LIGHT VALLEY SOLAR DEVELOPMENT CONSENT ORDER

Planning Inspectorate reference EN0110012

Deadline 3 Submission of Mrs Annette Exley

6 October 2026

Drawing Title
**Figure 15.27
Design Flood Extents with Site Layout
Sheet Number 5 of 7**

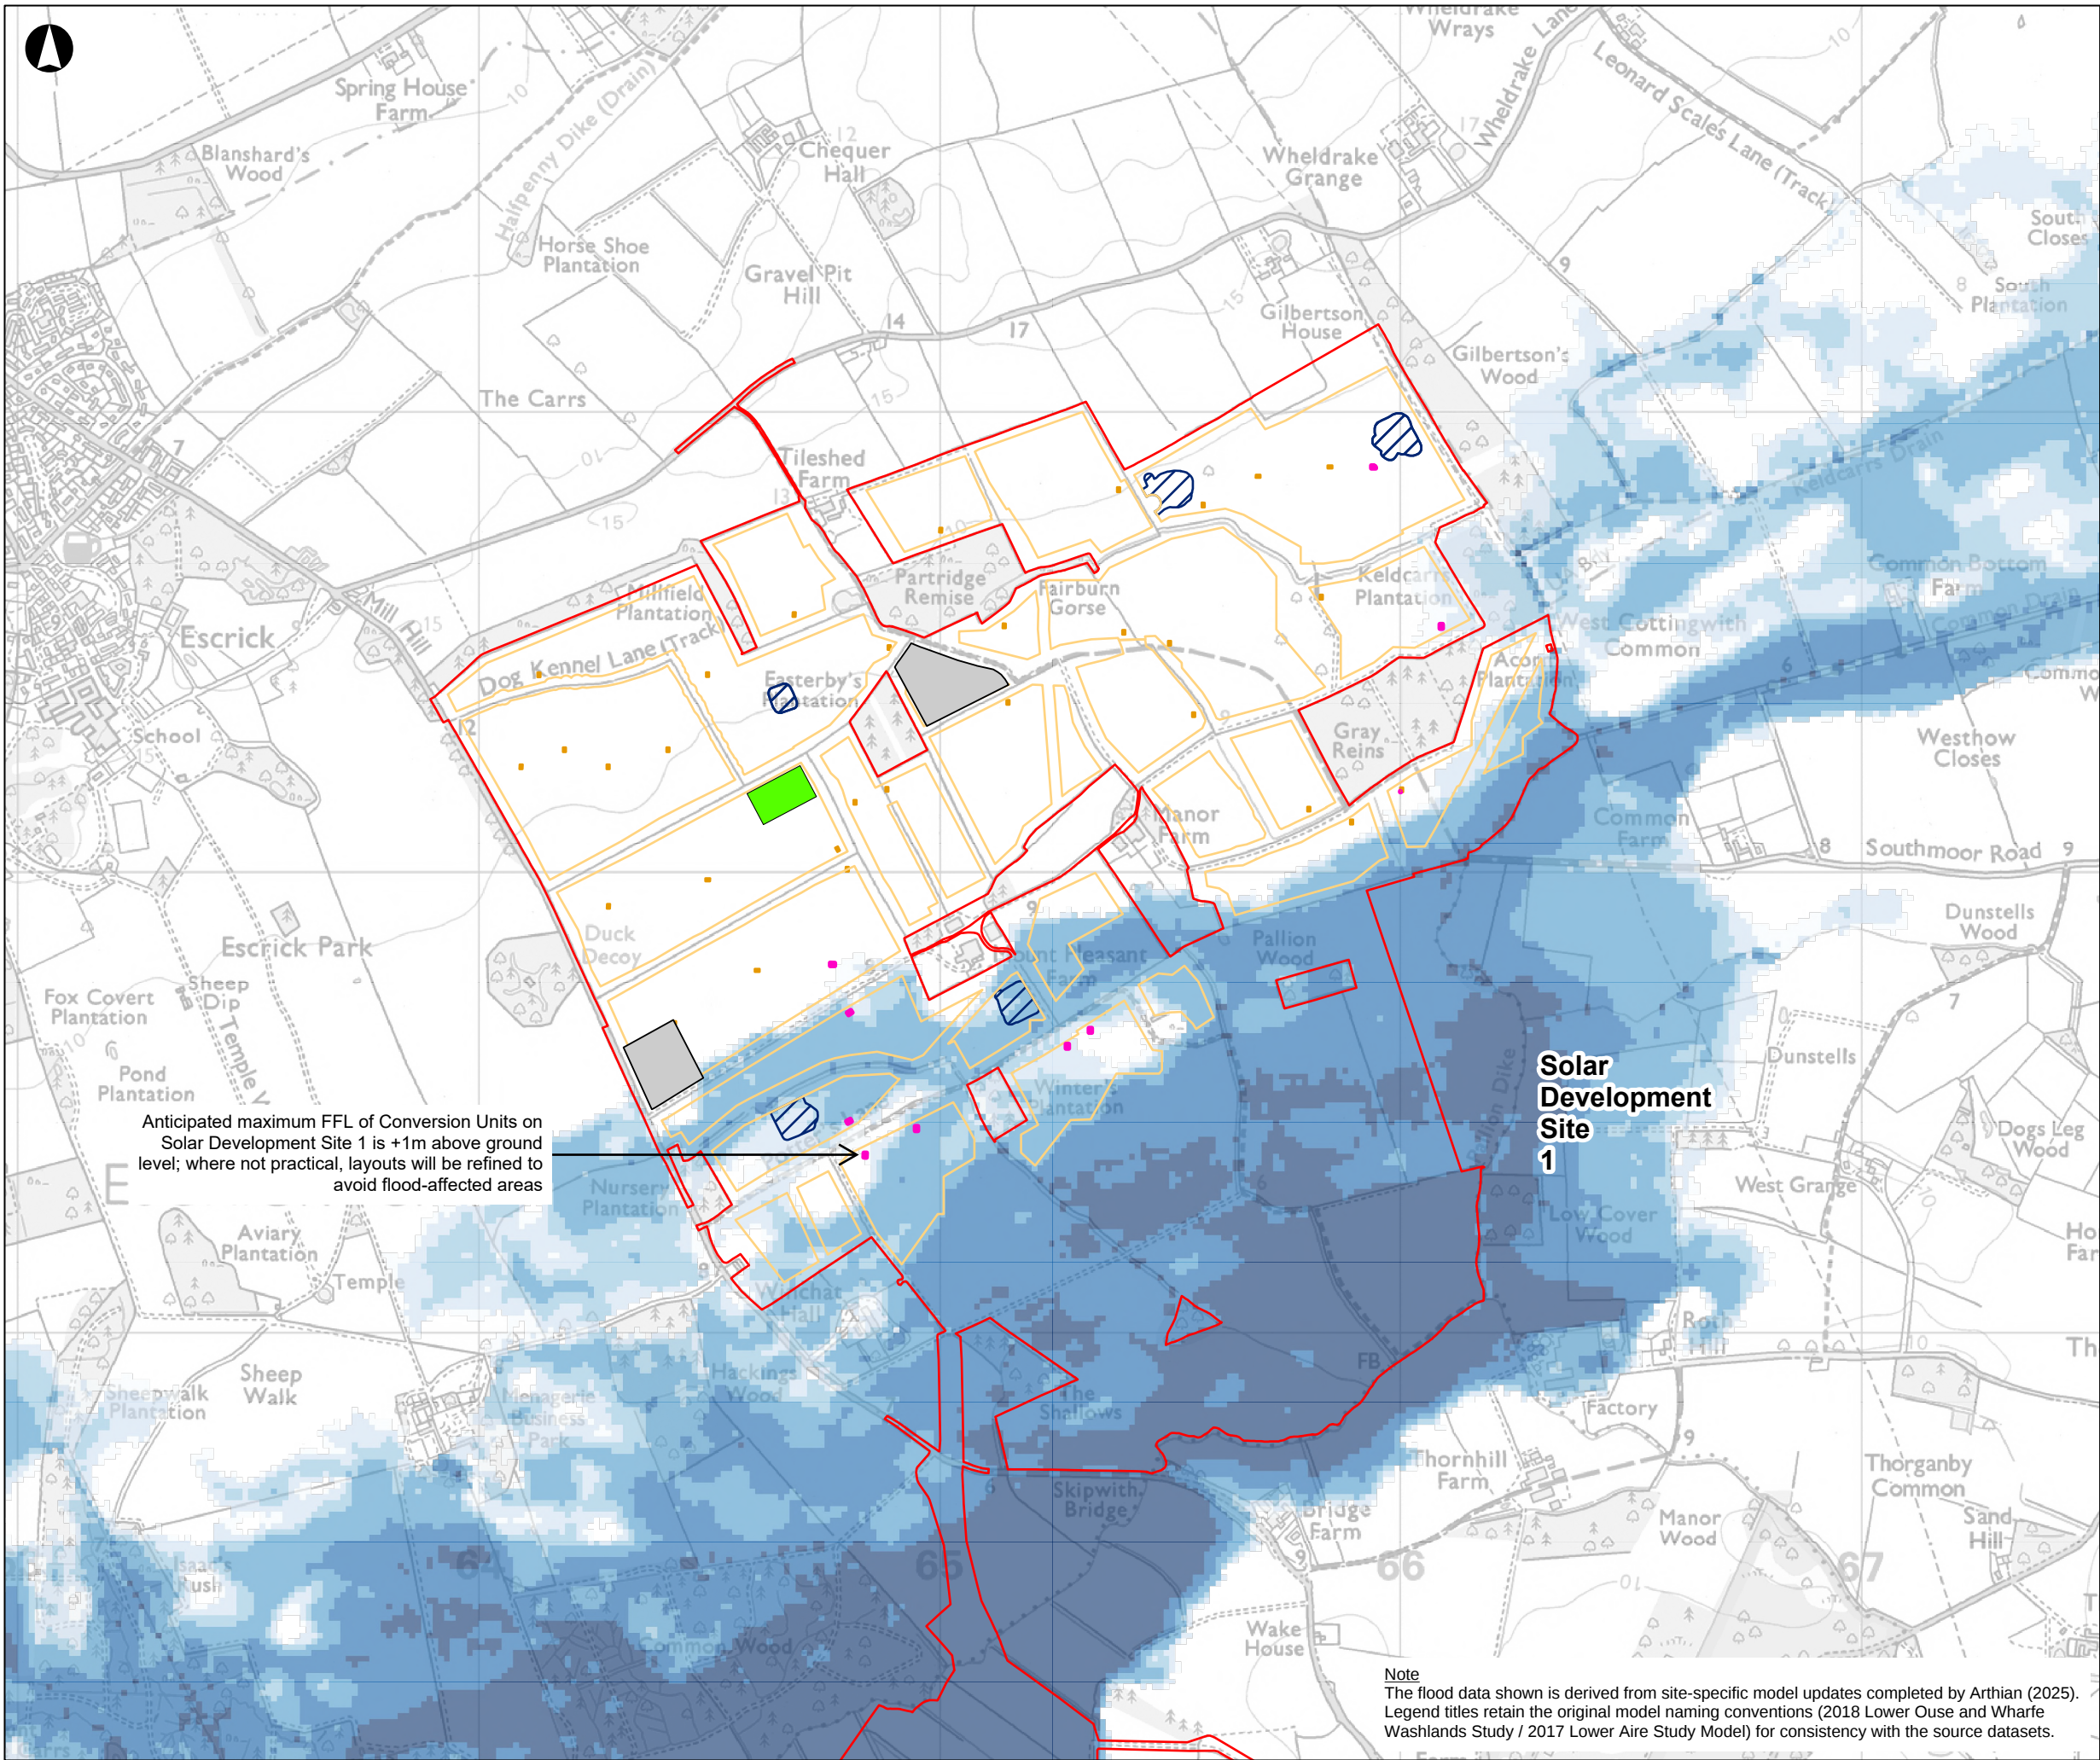
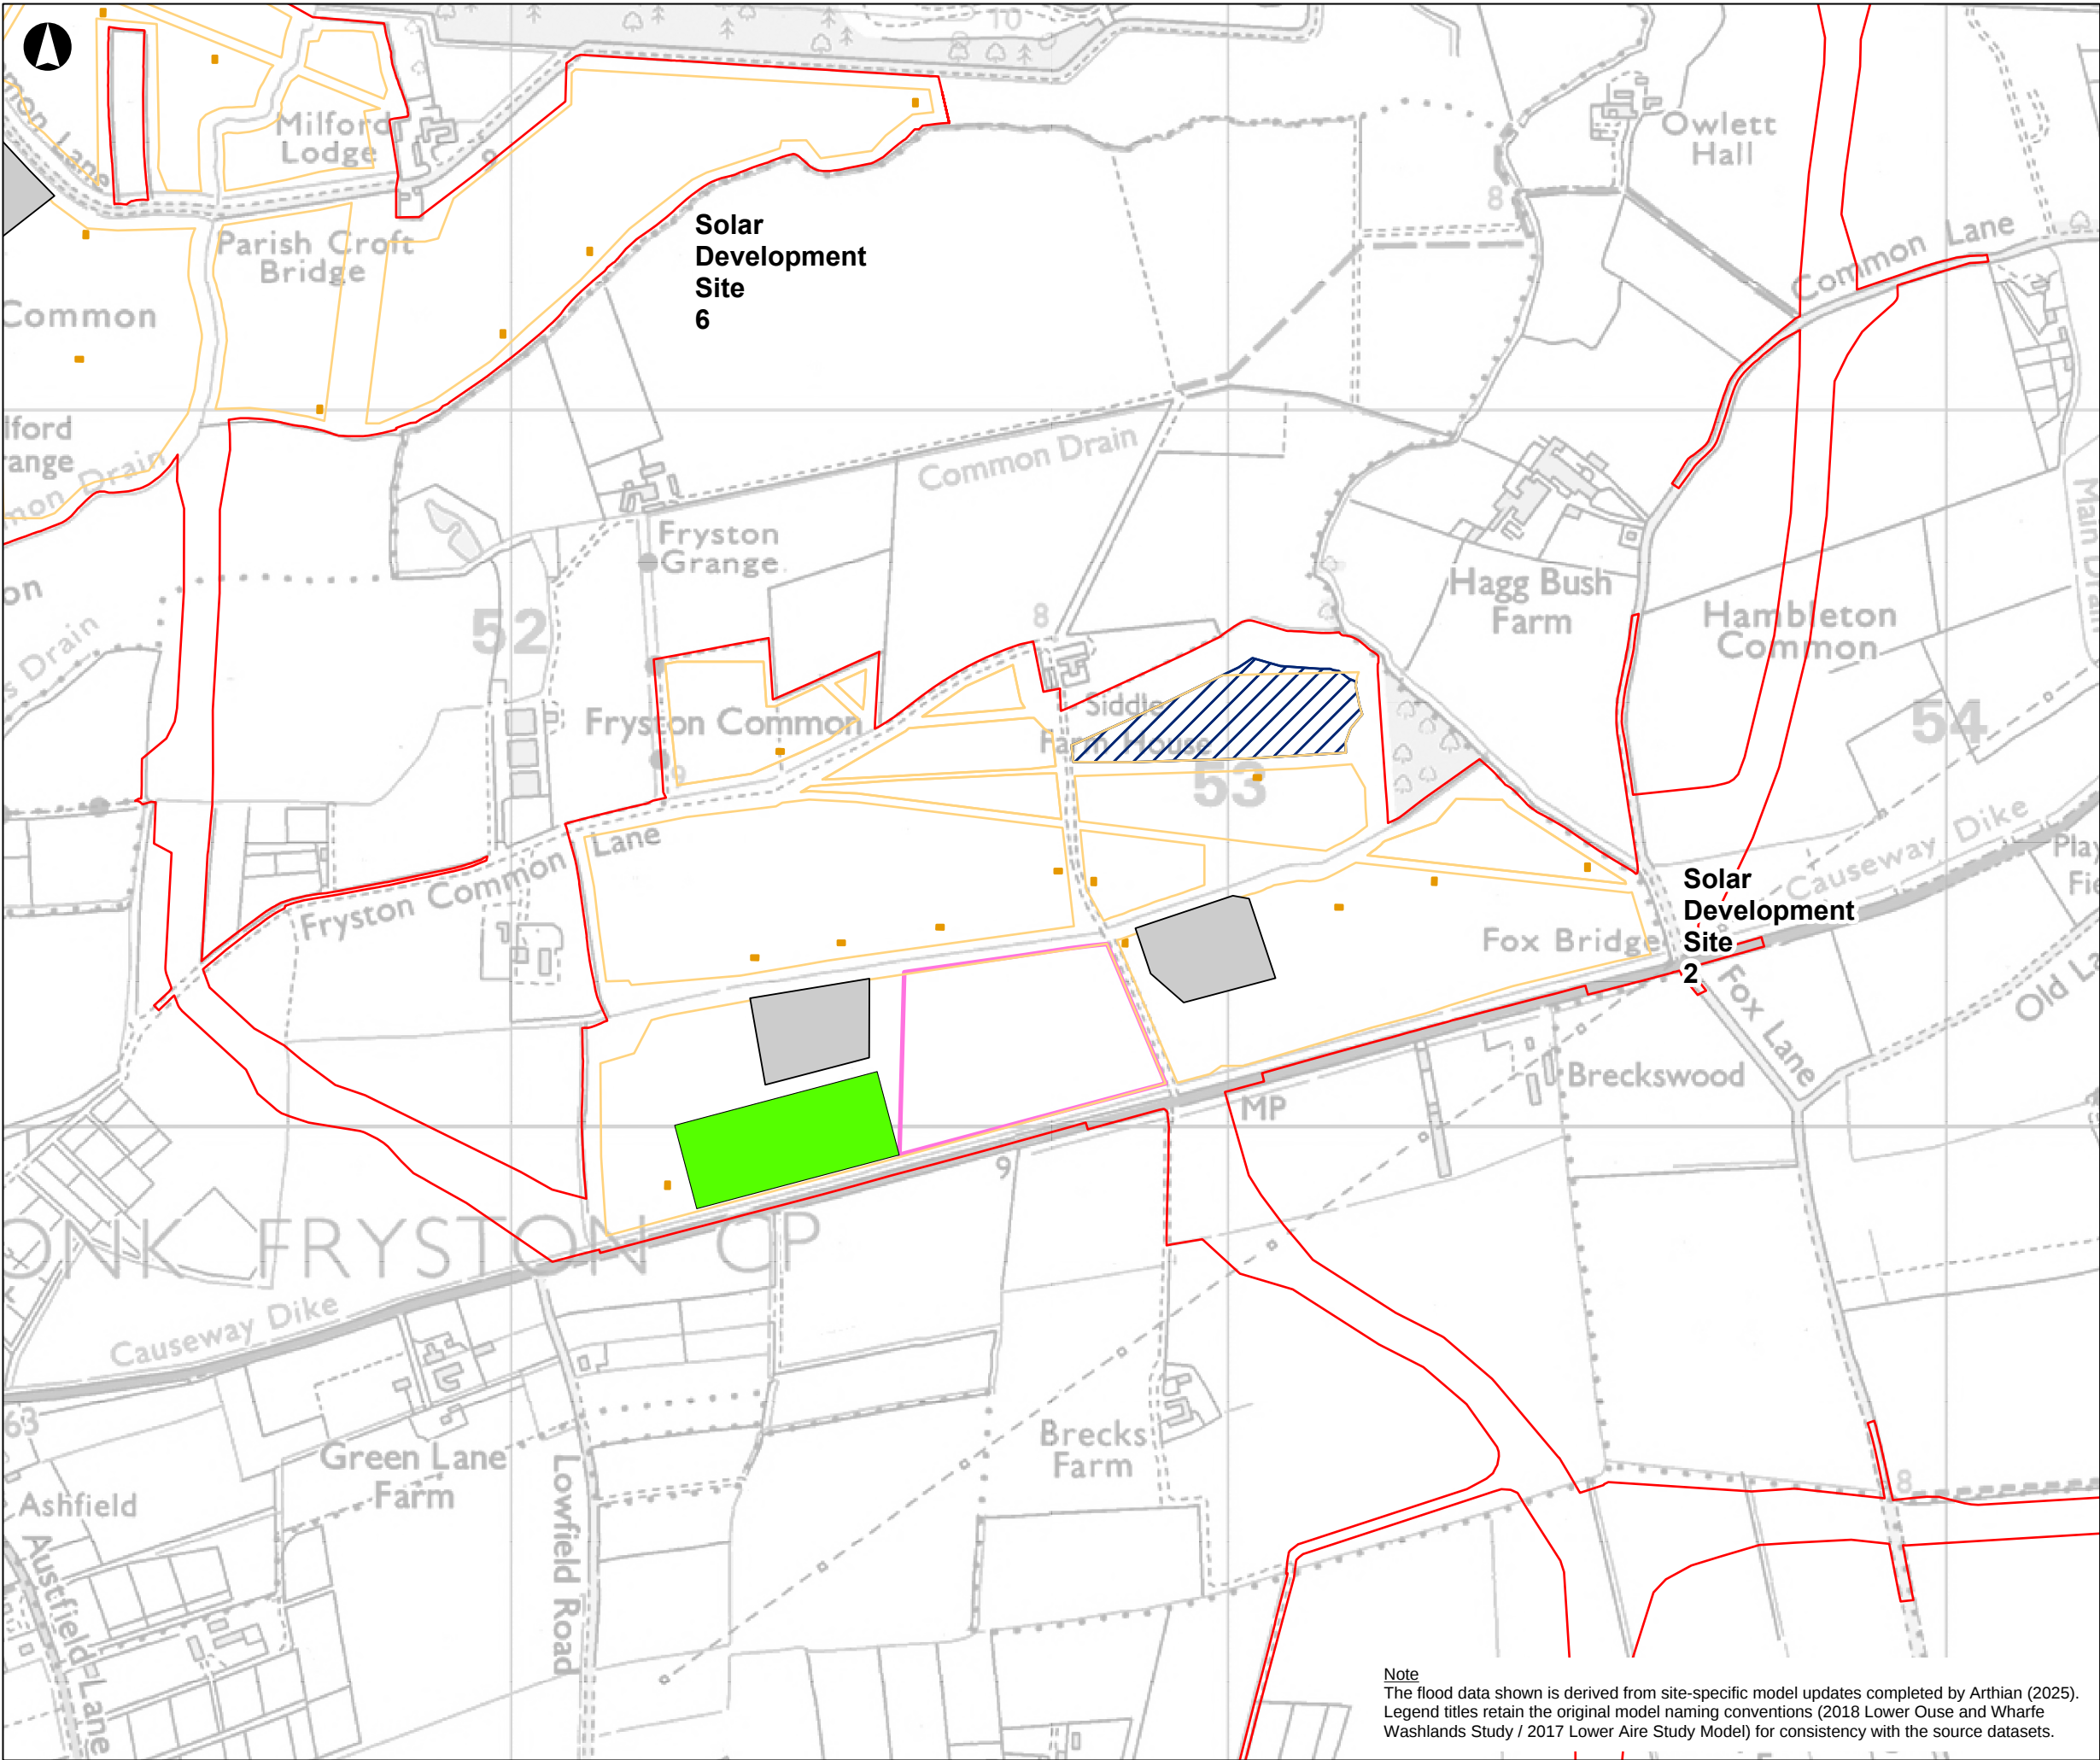
A.18 **[DF]** The anticipated maximum flood depth above ground level at the Solar Development Site 1 conversion units in the **design event** is **+0.5 m**. That figure appears nowhere in ES Volume 1 Chapter 15 [REP2-043], nowhere in Figure 15.27 [AS-041], and nowhere in the Applicant's response at [AS-040].

A.19 **[DF]** Paragraph 8.1.9 of the Flood Risk Assessment states that panels within the design flood extent at Site 1 "will be raised above the modelled design flood level in the corresponding location in accordance with the applicable freeboard parameters or, **where this is not practical**, panel layouts will be refined to avoid flood-affected areas". The same qualification appears on sheet 1 of Figure 15.27. I invite the Examining Authority to consider what secures either limb of that alternative.

B.2.1 **[DF]** The Examination Library records Chapter 15 figures as APP-115 (Figure 15.1) through APP-140 (Figure 15.26), each with an application-stage entry dated 10 February 2026. **There is no application-stage entry for Figure 15.27 or Figure 15.28.** They appear only as AS-041 and AS-042, additional submissions accepted at the discretion of the Examining Authority.

B.2.4 **[DF]** The drawings are stamped revision **P01** — first issue — dated 09/09/2026. The Guide to the Application [AS-038] logs both as "Version 2.0". There is no Version 1.0 of either.

B.2.6 I invite the Examining Authority to require the Applicant to state whether Figures 15.27 and 15.28 form part of the Environmental Statement; if they are to be certified, by what mechanism they are to enter Schedule 13; and why a first-issue drawing has been logged as a second version.

B.2.7 **[DF]** Figure 15.27 is published in six sheets, numbered "Sheet Number 1 of 7" to "Sheet Number 6 of 7". **Sheet 7 of 7 is not published.** The sheet-location index in the corner of all six published sheets shows seven panels. **[RI]** The six published sheets cover all seven solar development sites, which leaves the cable route corridor as the likely subject of the missing sheet — that is, the one location the Applicant now accepts is within functional floodplain. I do not know what sheet 7 shows. I invite the Examining Authority to require its production and to require the Applicant to confirm what it covers.
